Department's comments

Process Flow Diagram and Representation of equipment list issued for relocation

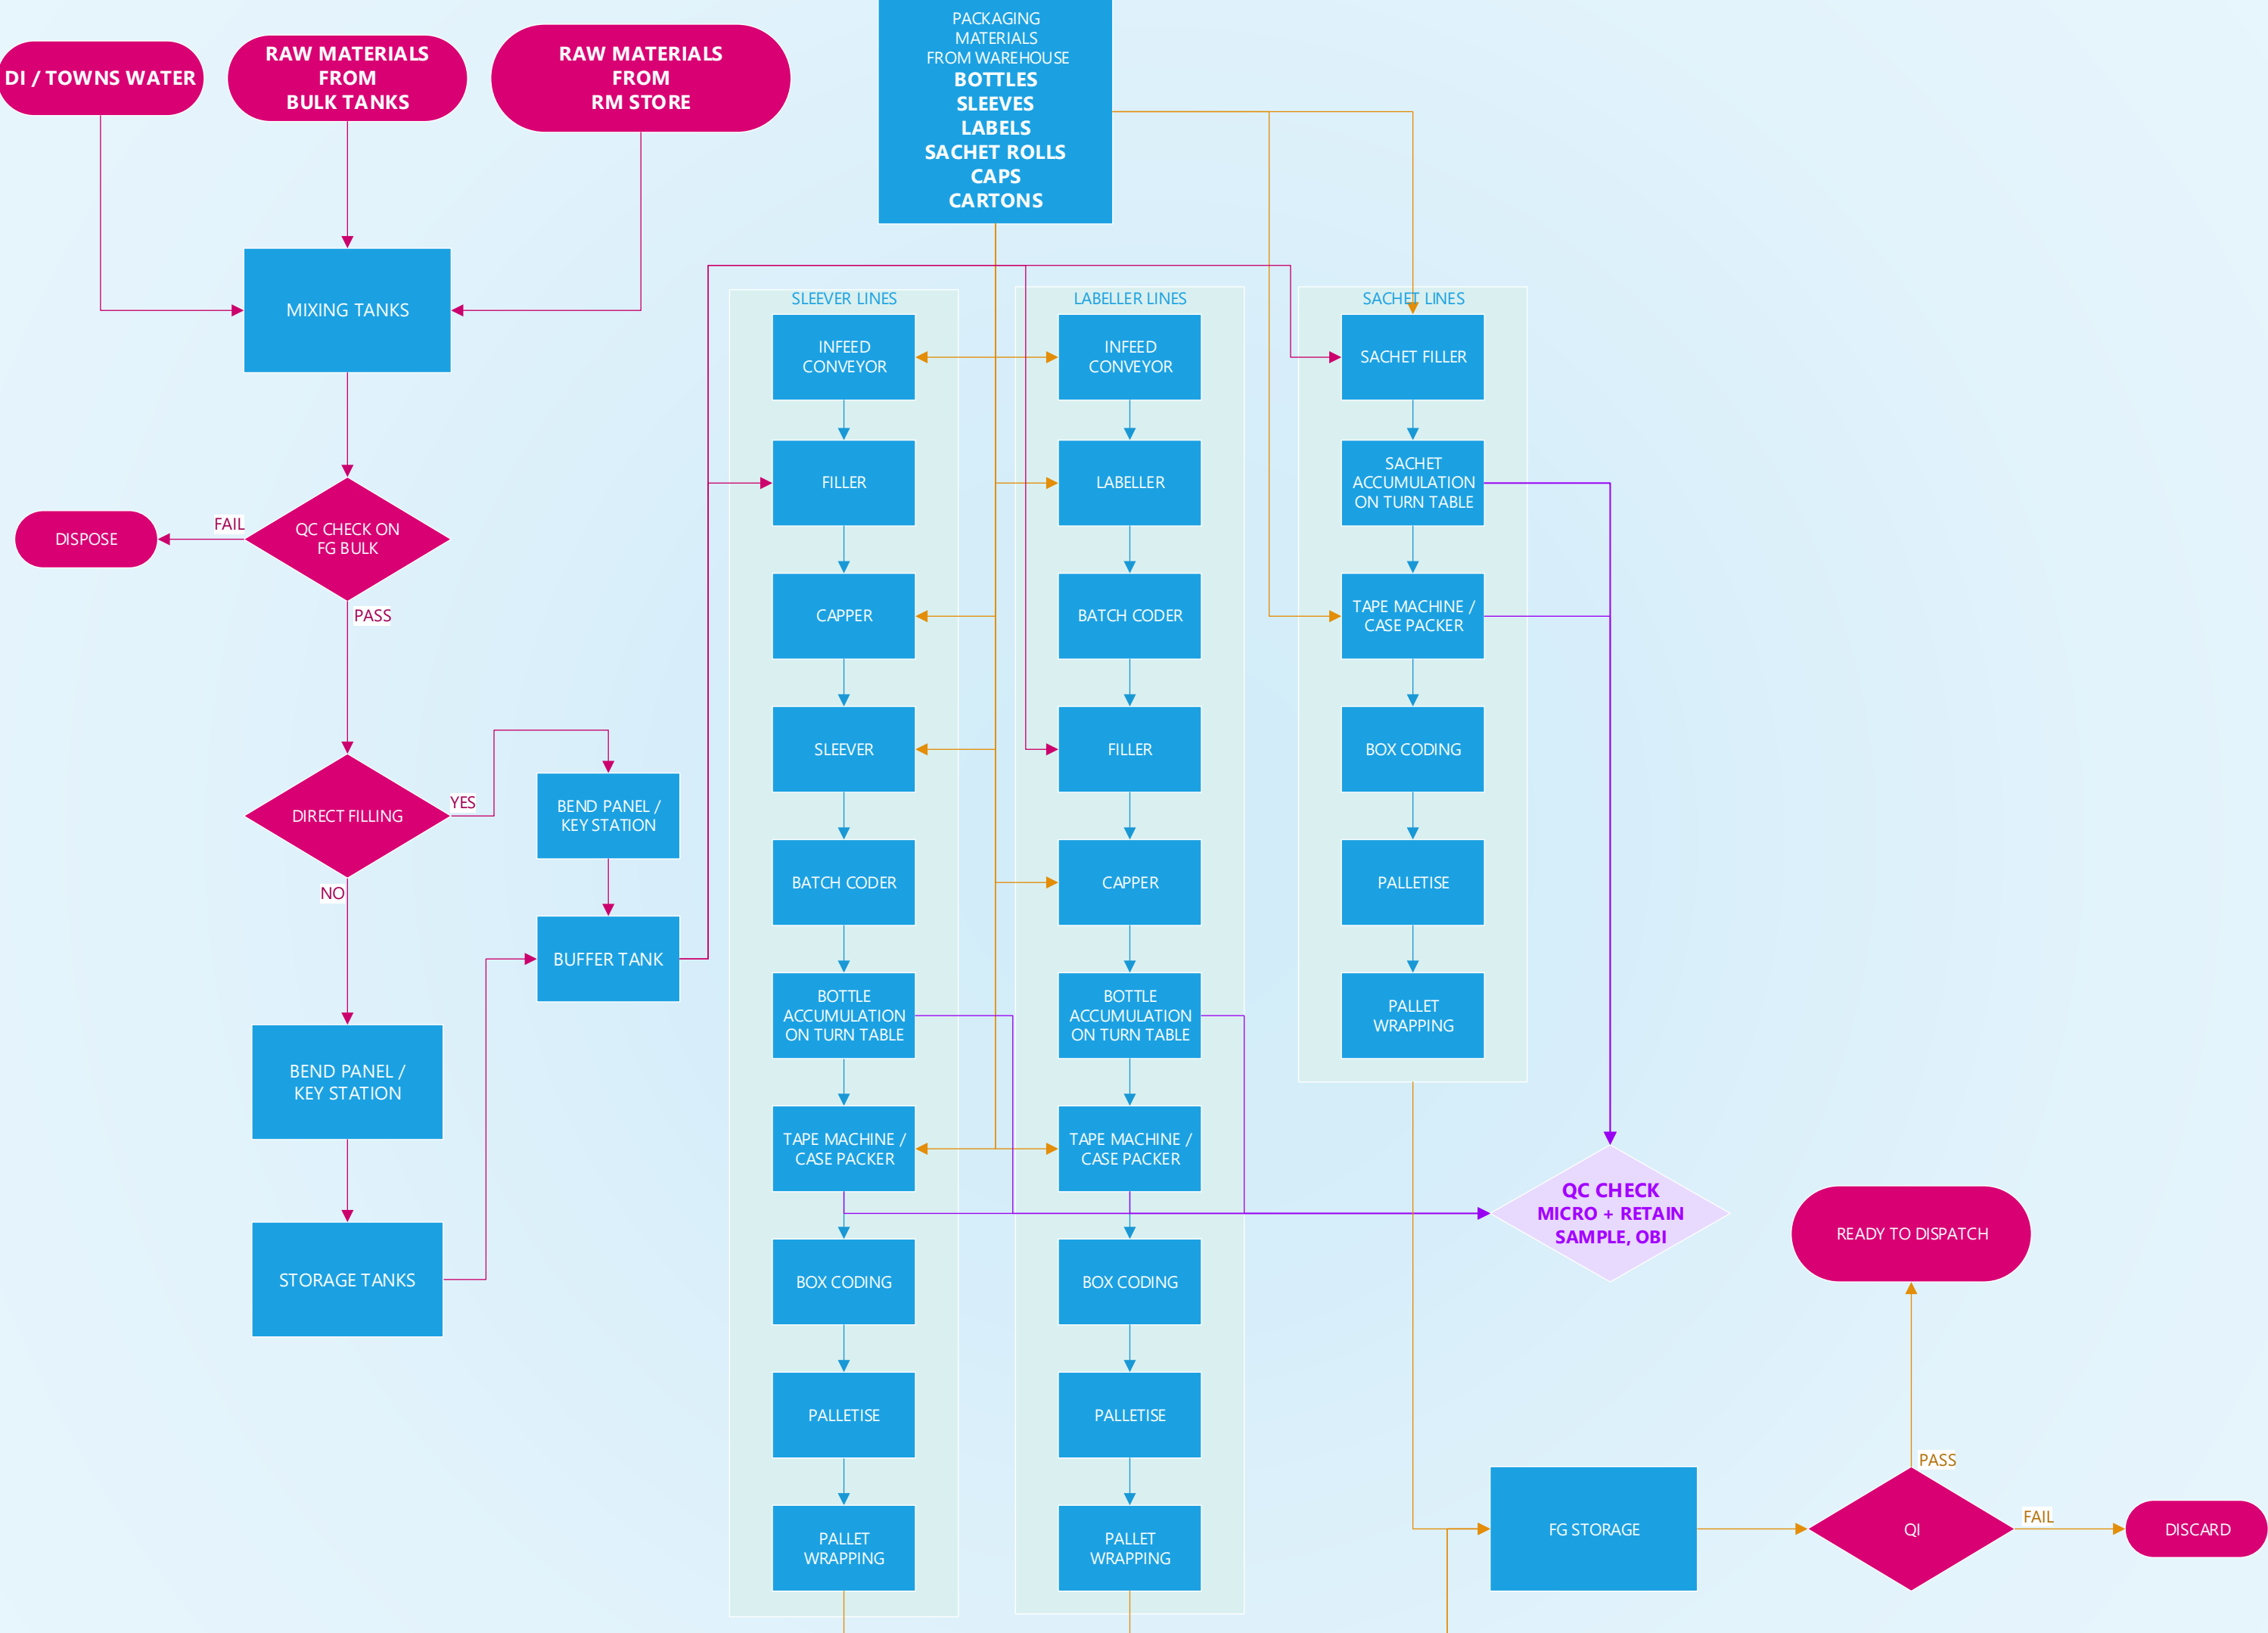
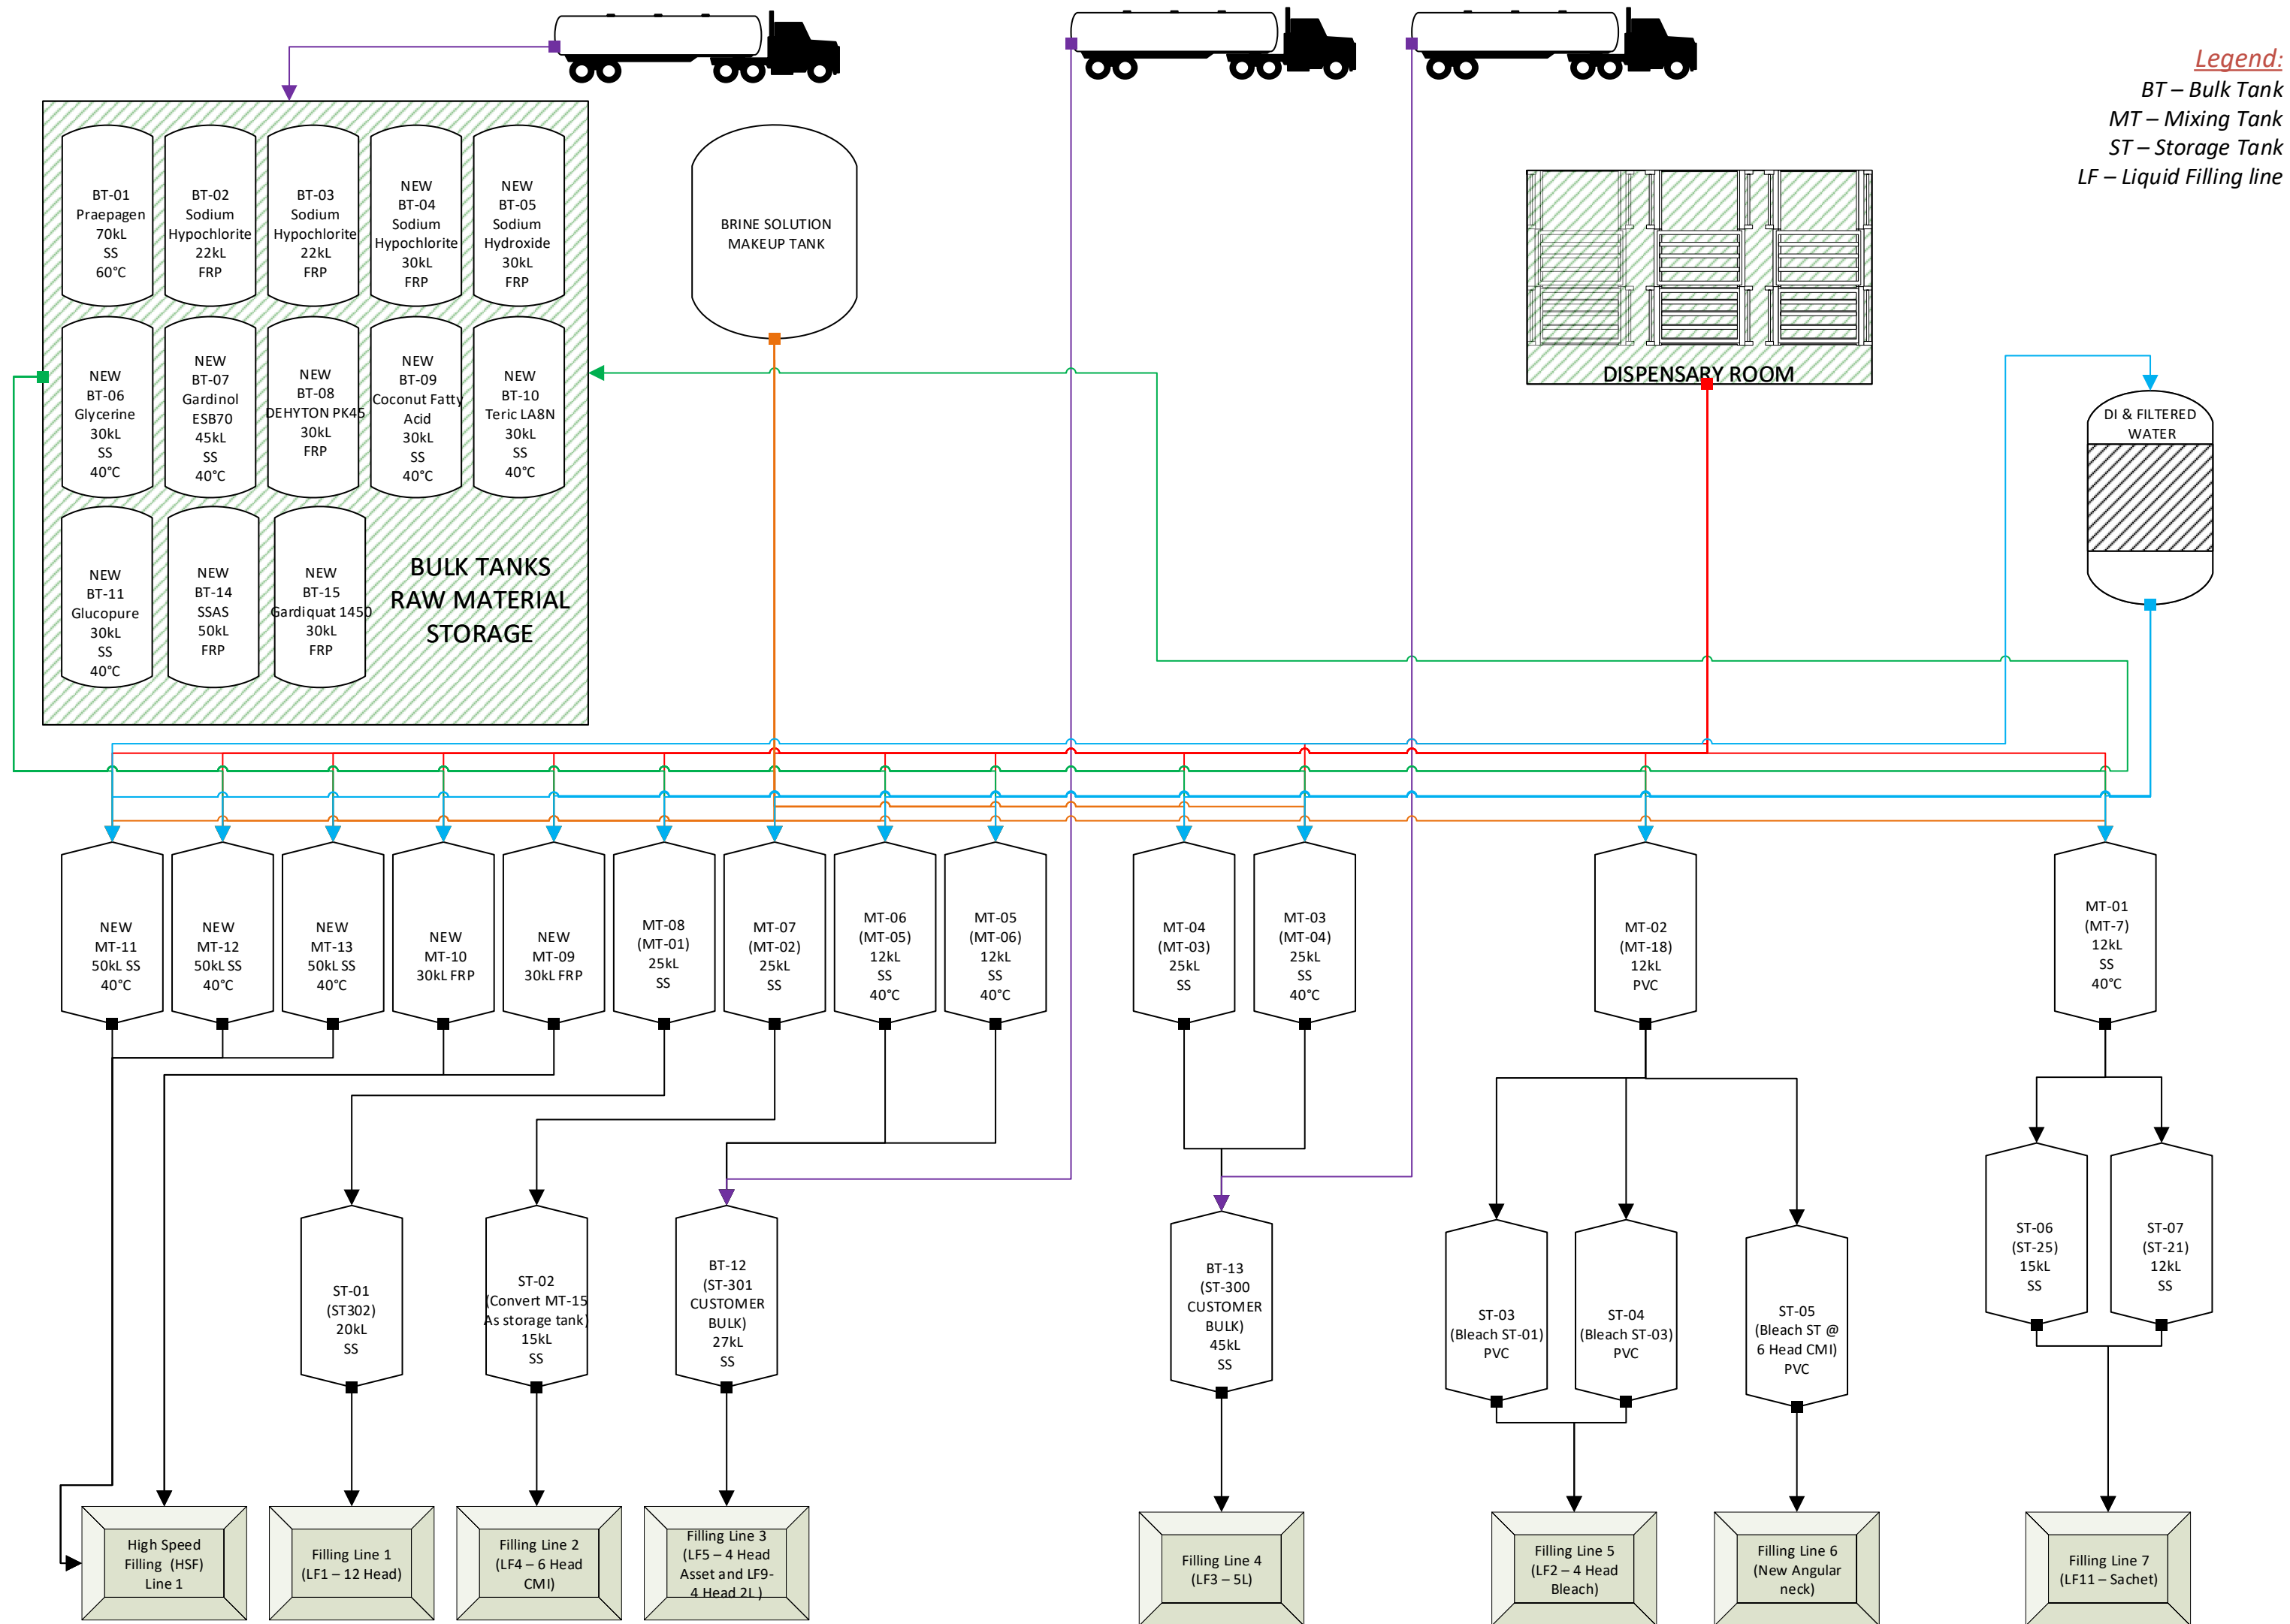
- A breakdown of vehicle movements including heavy vehicles.
- The Process Flow Diagram at Appendix S contradicts the information in the EIS relating to production capacity and employee numbers:

- The EIS suggests the site would have 60 staff and have a production rate of 4000 tonnes per year. Please clarify this contradiction.
